September 25, 2023

Re: 12710 San Jacinto
12710 San Jacinto Ave. NE
30-Day Temporary Certificate of Occupancy
Transportation Development Final Inspection
Architect's Stamp dated 04-19-22 (K22-D063)
Certification dated 09-18-23

Date: April 19, 2022  
Sheet: Site Plan

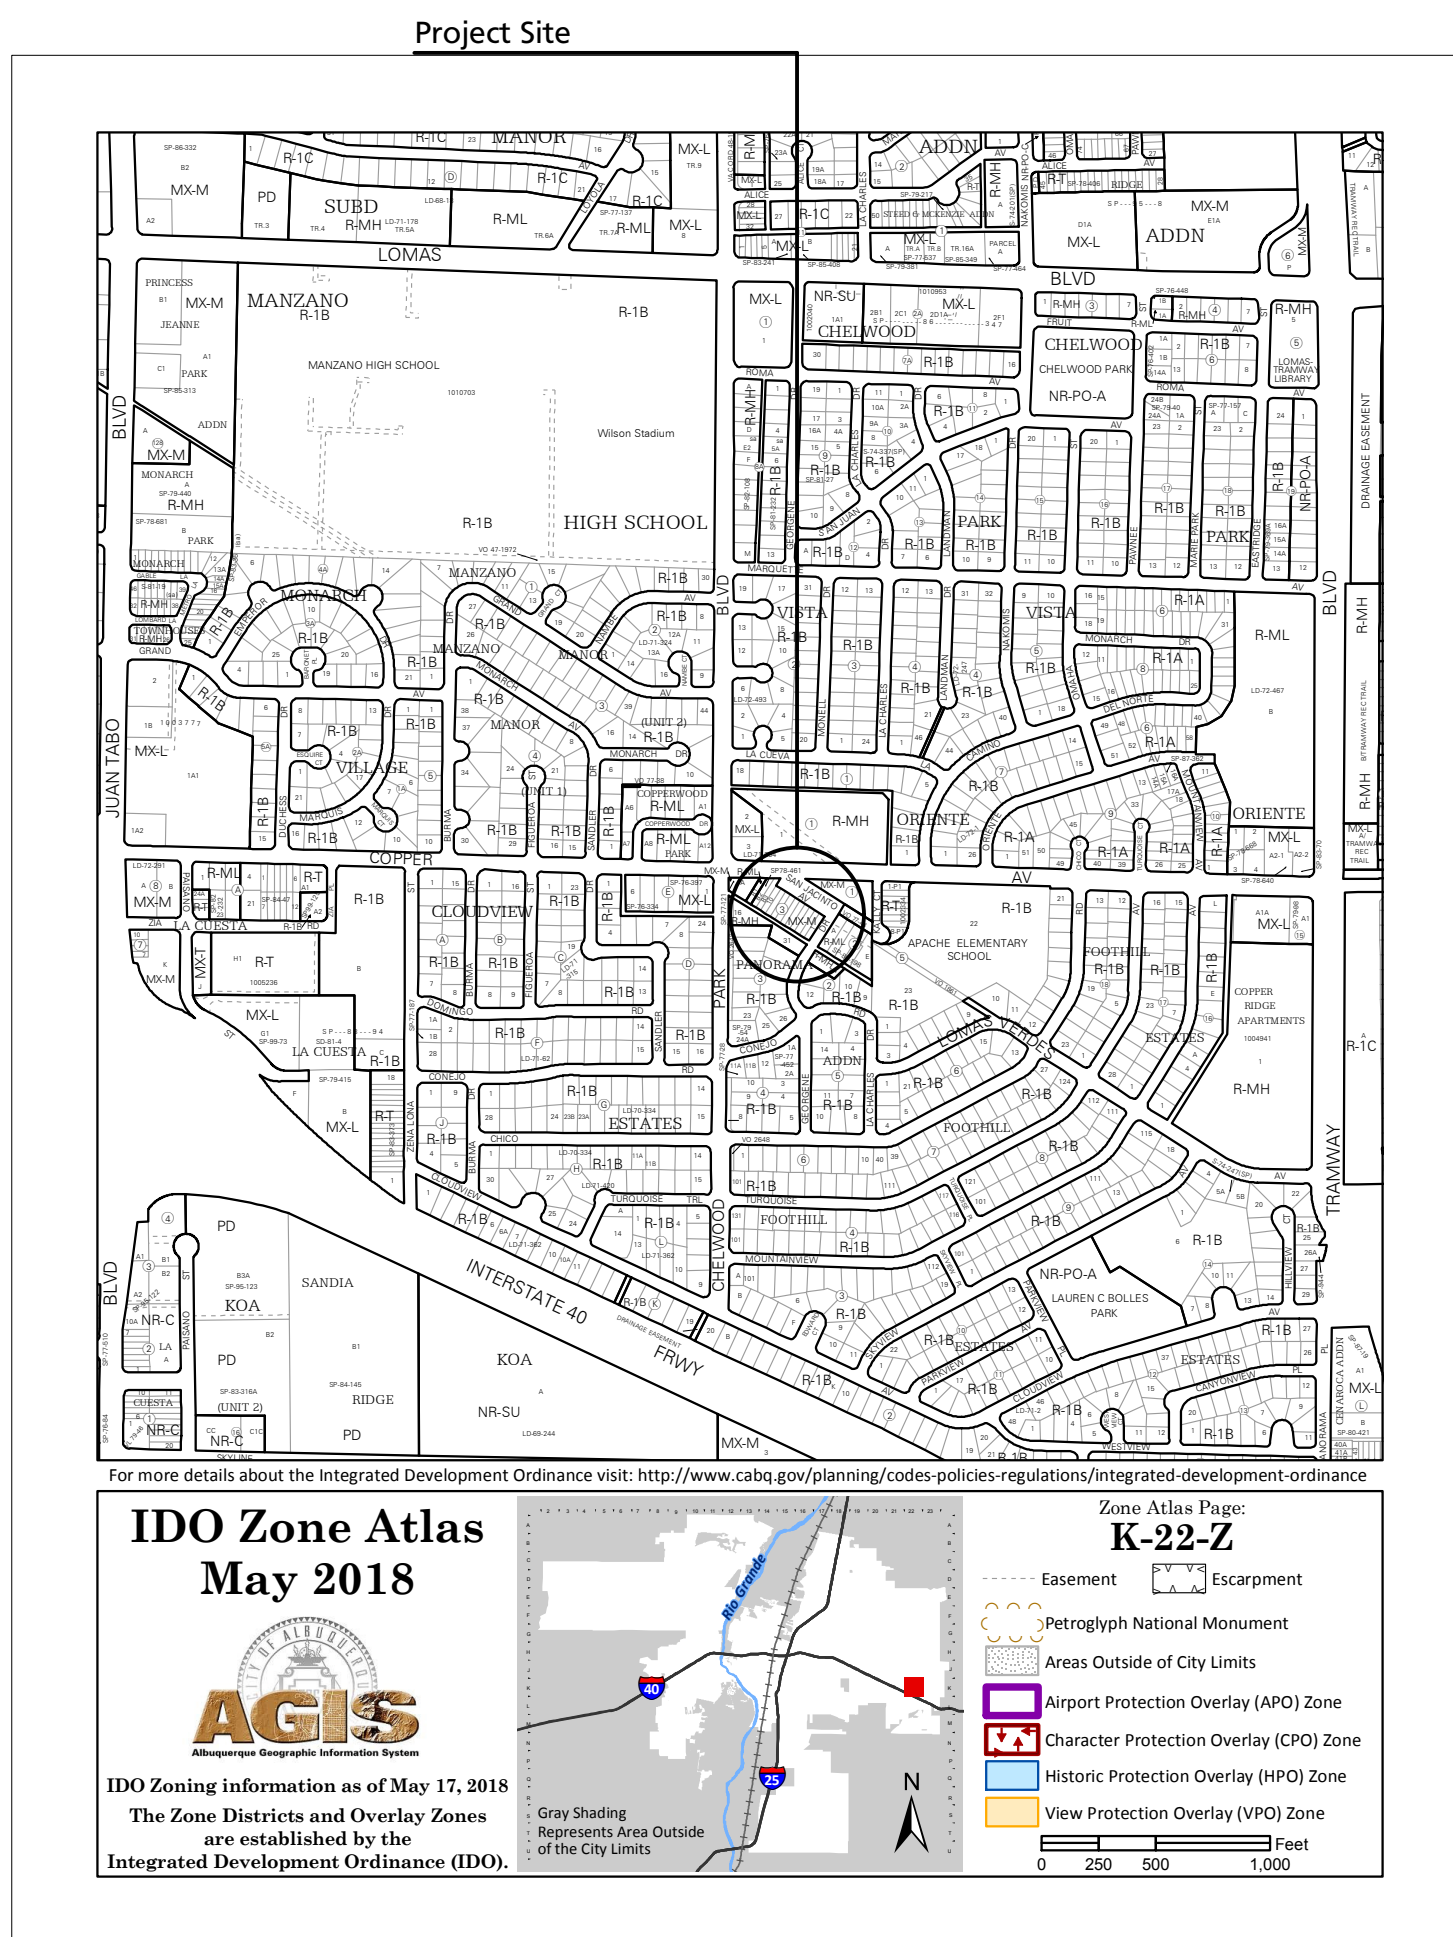
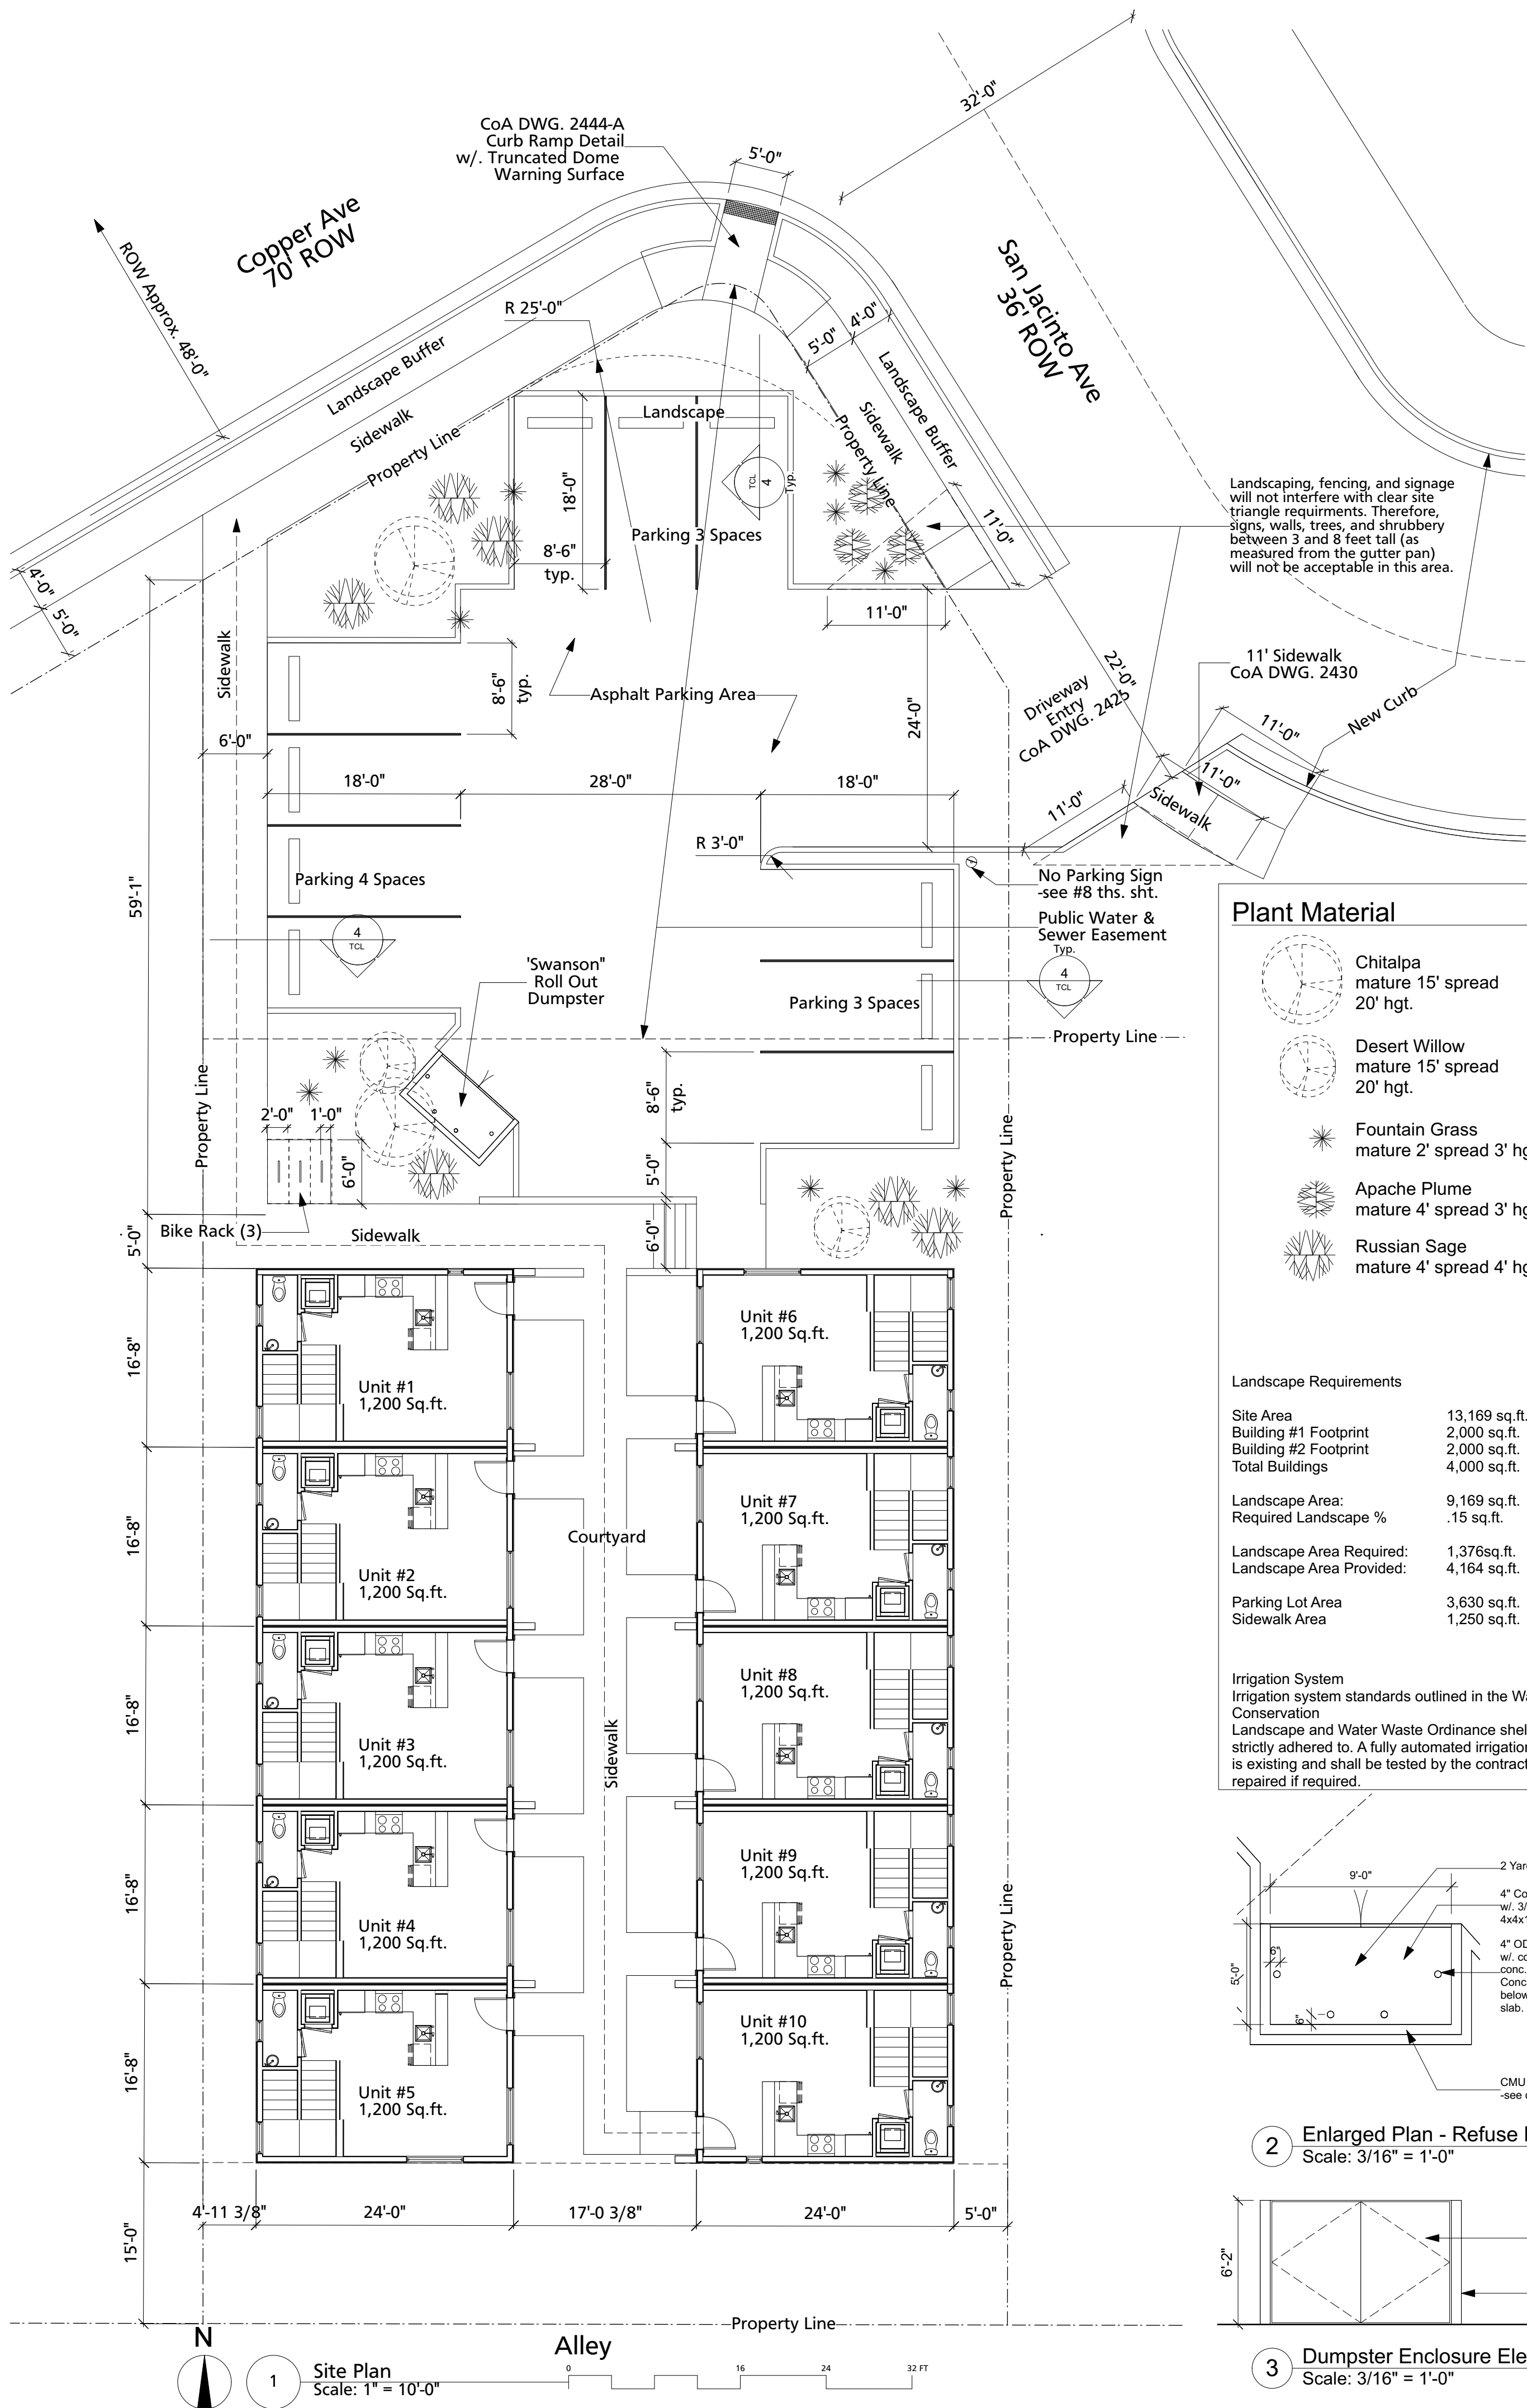
- Per site visit, the cross slope for the pedestrian pathway from the public sidewalk to the building entrance ranges between 2.6-5.9%. The maximum cross slope should be 2%.

- Please anchor down the Bike Rack.
